**New Request for Advice – Sydney Business Park – Stage 3  
(SSD-10477) (Blacktown)**

## TAB A - TfNSW comments on SSD-10477 Sydney Business Park, Stage 3 EIS

Title: ROUNDABOUT VEHICLE TURNING PATH PLAN SHEET 01 OF 03				
Project No.	Set No.	Milestone	Plan	Revision
20-0127	02	DA	600	A

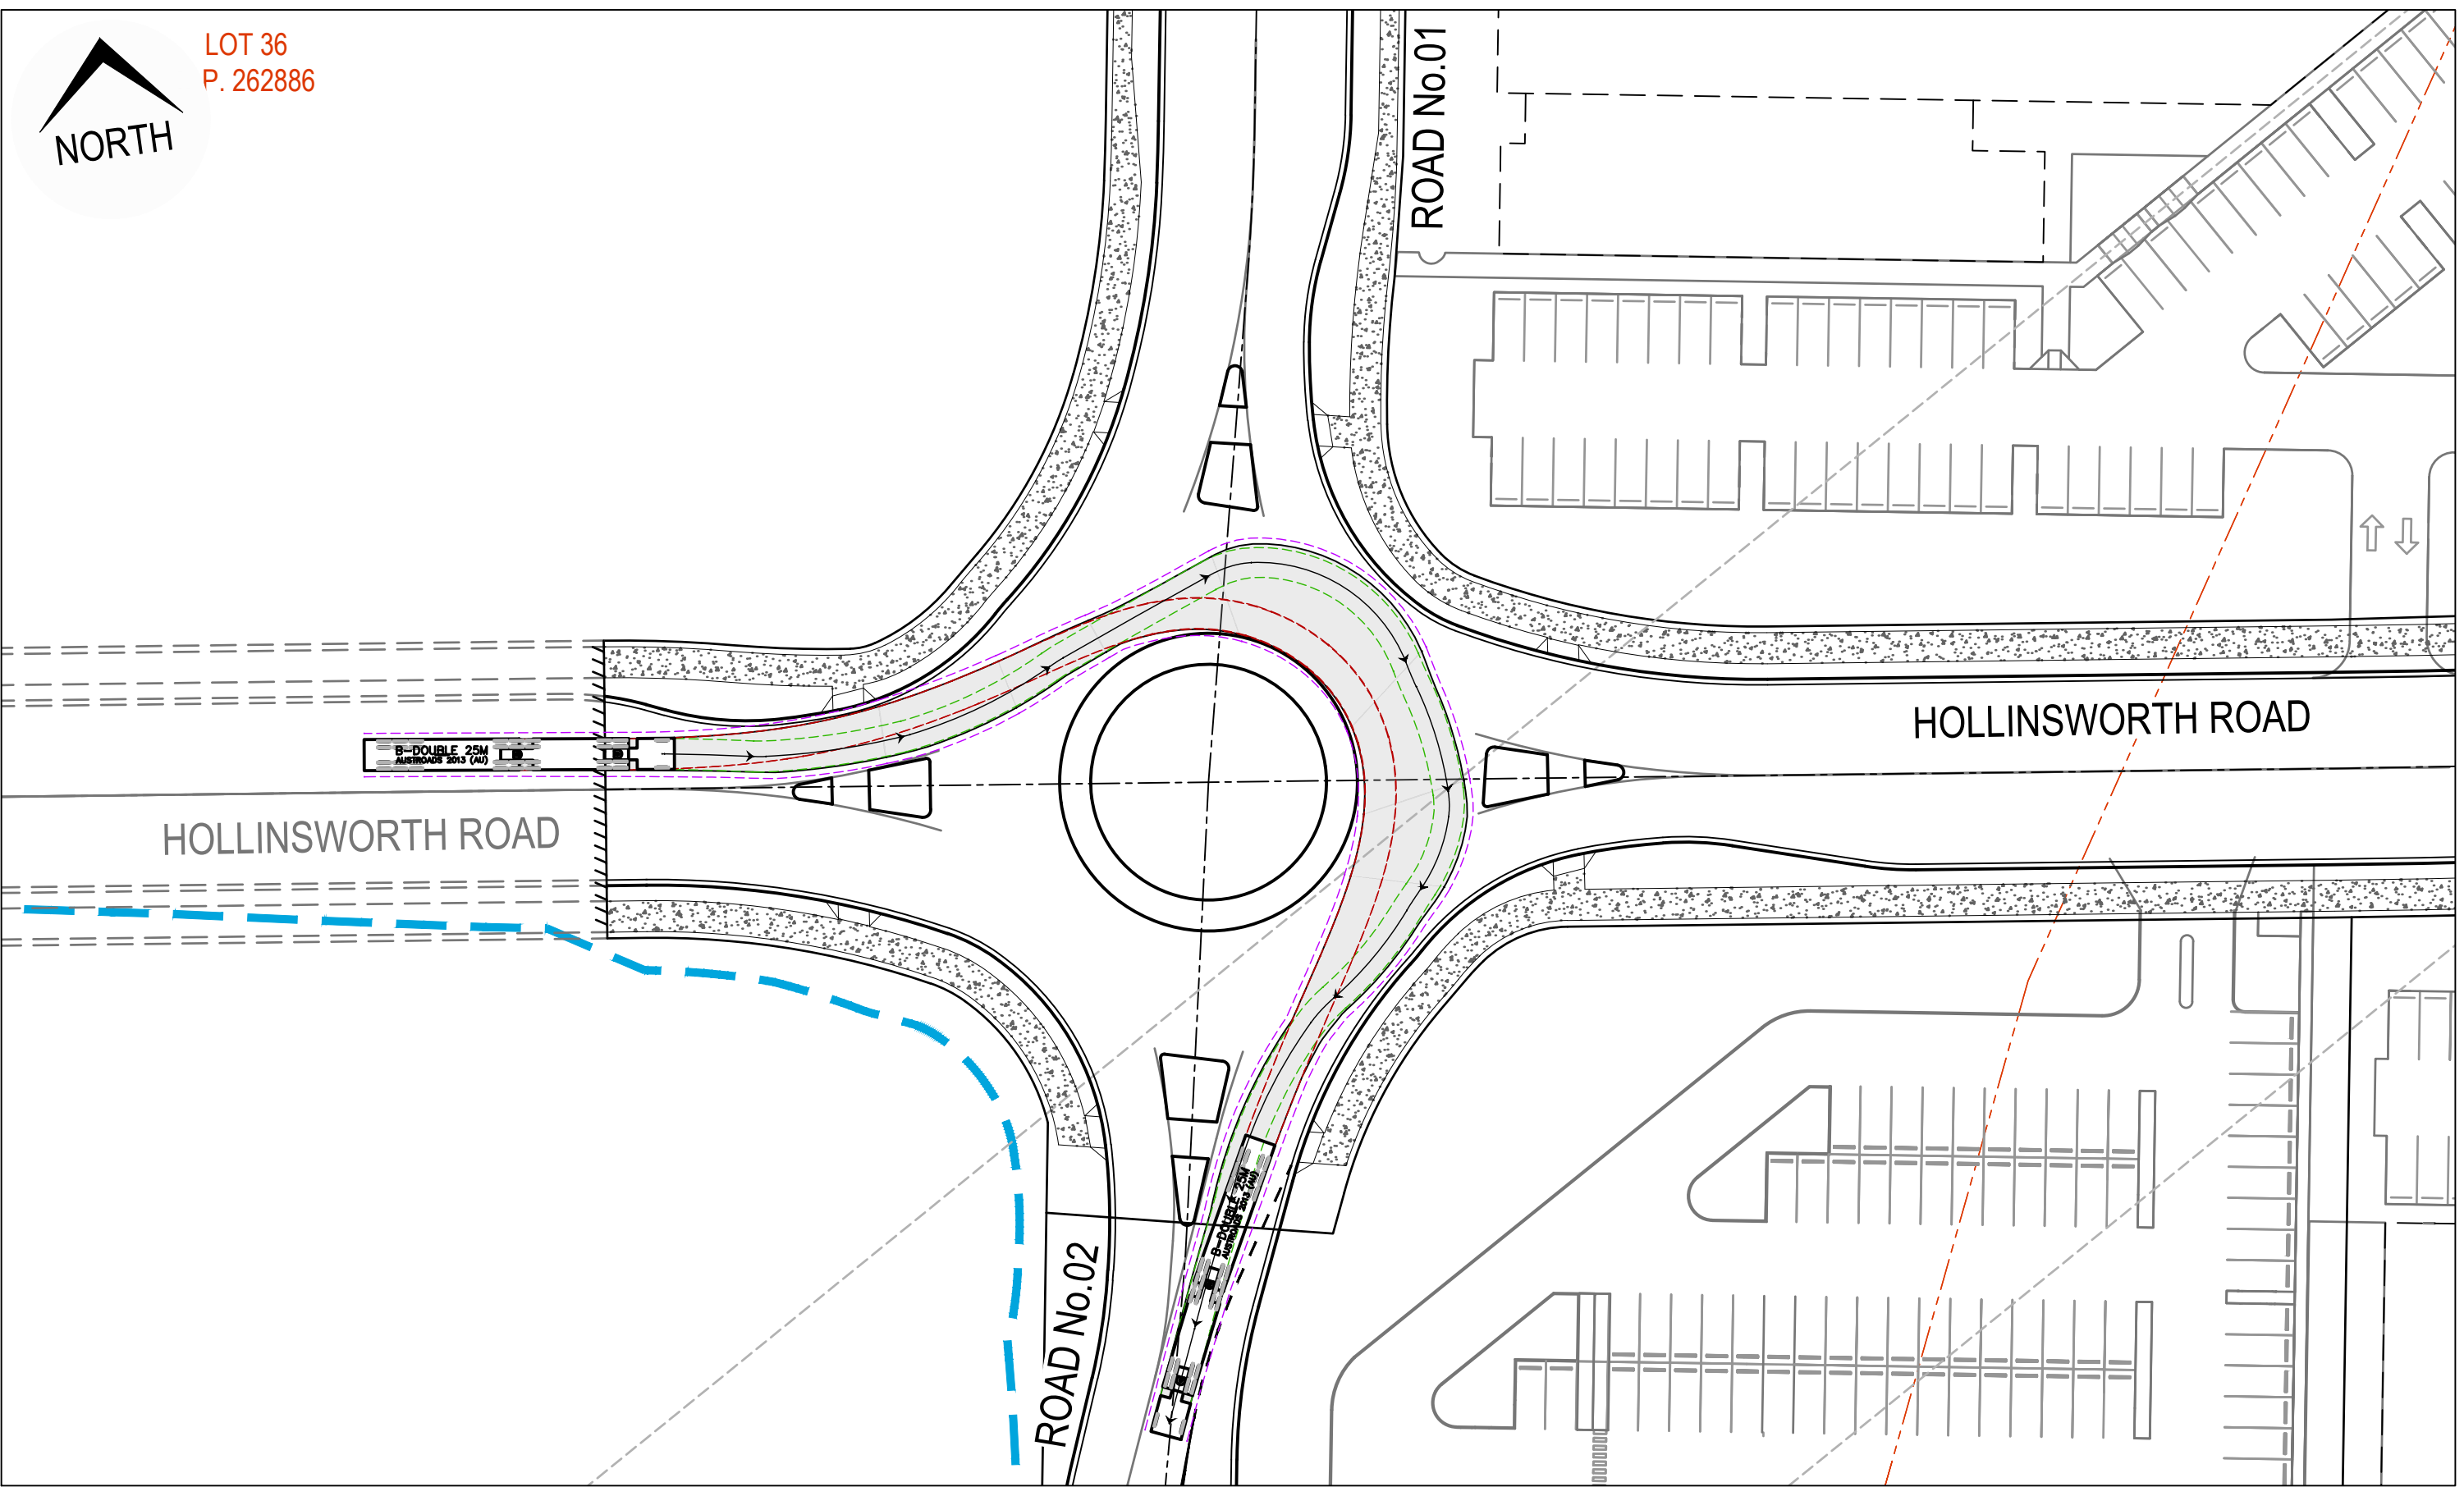
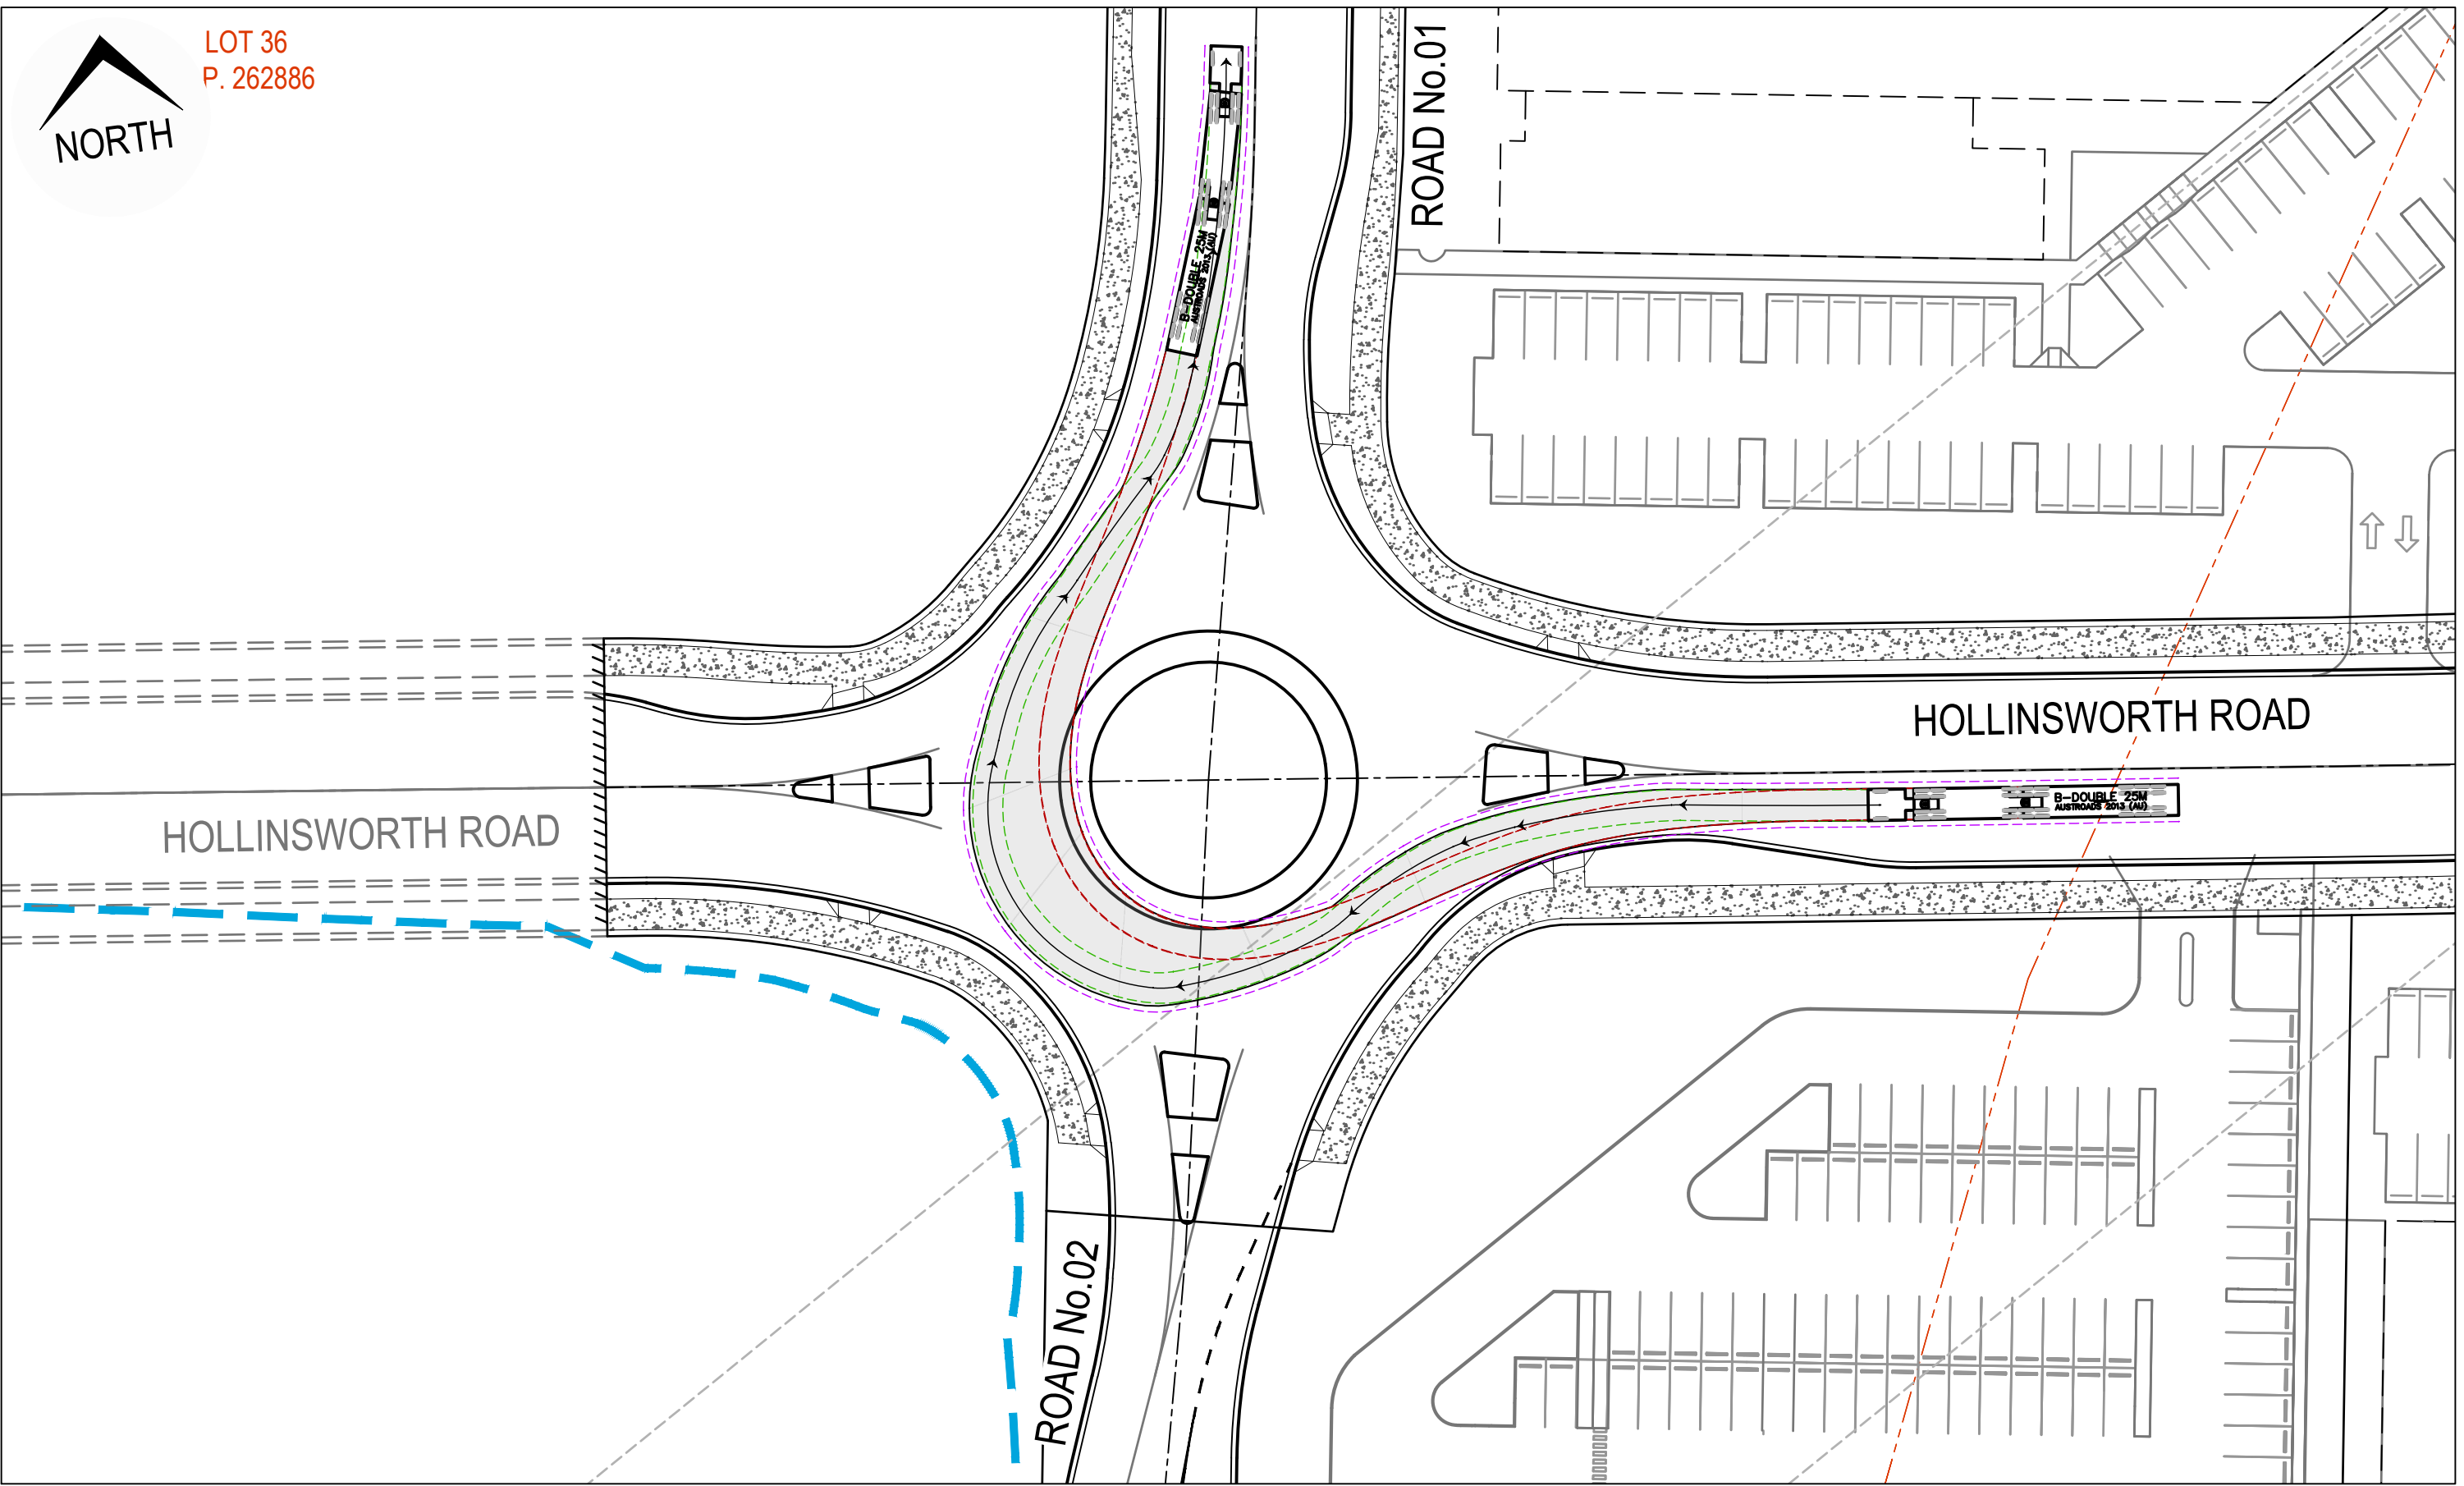
TfNSW notes that the provided swept paths for B-Doubles overlaps with the kerbs at the roundabout and at exit/entry locations of all the warehouses.

It is requested that updated swept paths of the longest vehicle (including garbage trucks, building maintenance vehicles and removalists) entering and exiting the subject site, as well as manoeuvrability through the site are to be provided and shall be in accordance with AUSTRROADS. In this regard, a plan should be submitted to Council for approval, which shows that the proposed development complies with this requirement and shows how vehicles can manoeuvre safely whilst ingressing/egressing the site as well as manoeuvrability within the site.
